**RE:** Taco Bell Heritage Marketplace  
Grading and Drainage Plan  
Engineer's Stamp Date 1-11-2017 (File: H09D026)

Based upon the information provided in your submittal received 1-11-2017, the above referenced Grading and Drainage Plan cannot be approved for building permit and site plan for building permit until the following comments are addressed:

## GRADING AND DRAINAGE PLAN

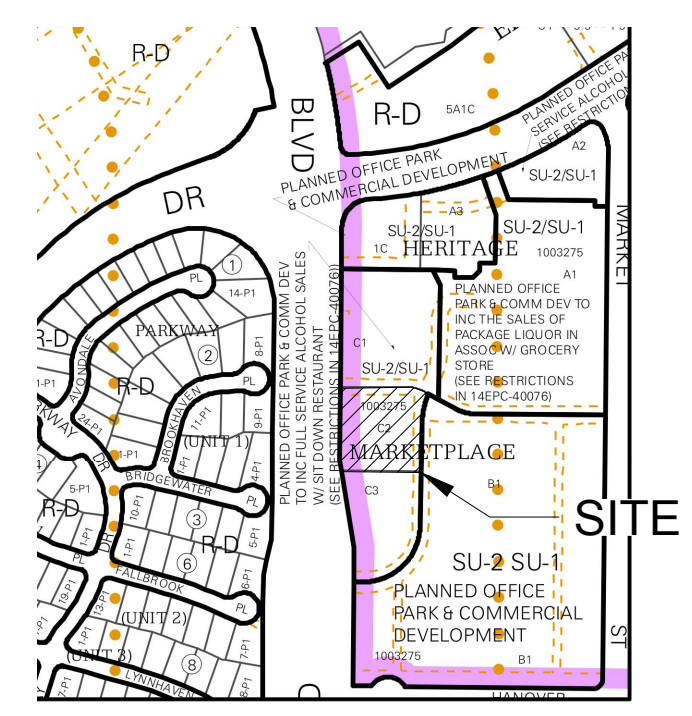
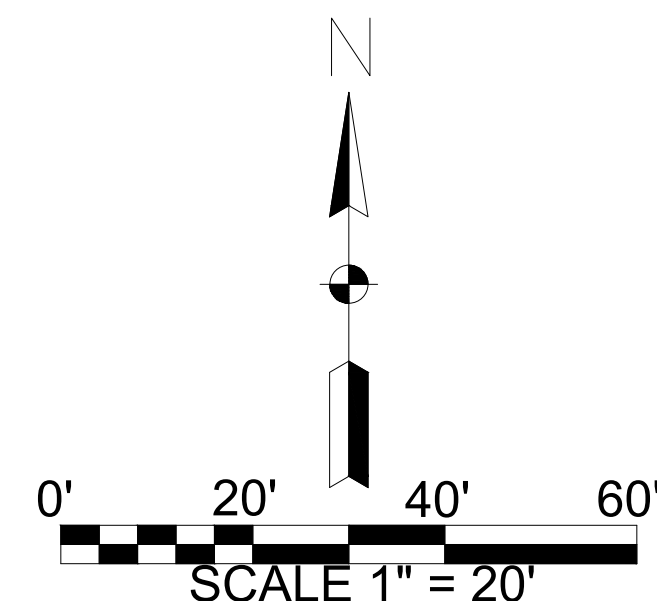
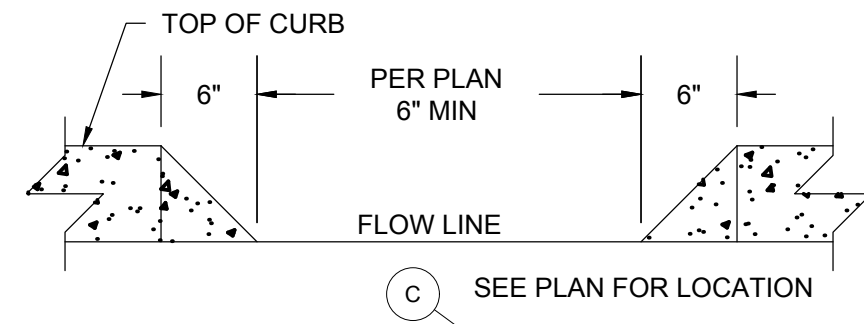
1. Per the approved drainage report for Heritage Market Place stamp date 3-25-15 this site is allowed 2.1 cfs.  
Provide significant offsite flow calculation that shows this site does not exceed the 2.1 cfs
2. Provide volume of stormwater quality for each pond and show the bottom elevations of ponds.
3. Provide direction of roof flow.
4. Provide volume of runoff calculations for existing and developed conditions.
5. Provide drain with grate elevation for trash enclosure that drains to grease trap then to SAS.
6. Provide detail grades for trash enclosure.

1. Benchmark.
2. Provide a legend for the property line. Include boundary information.
3. It appears the middle of the parking lot does not drain to a stormwater quality pond. A curb cut(s) on the eastern landscape area may work.
4. It seems a 6 inches curb cut is too small. Consider increase to 1 foot or provide weir calculations that shows 6 inches curb cut has capacity.
5. Provide exist spot elevation at the top of curb on the north side drain ally to aid in the determination of TOW grades.
6. Sidewalk slop on the north side of the site is too steep.
7. Southerly entrance appear to have a curb opining at elevation 77.25. Please provide note and detail.

8. Depressed all landscaping area where possible.
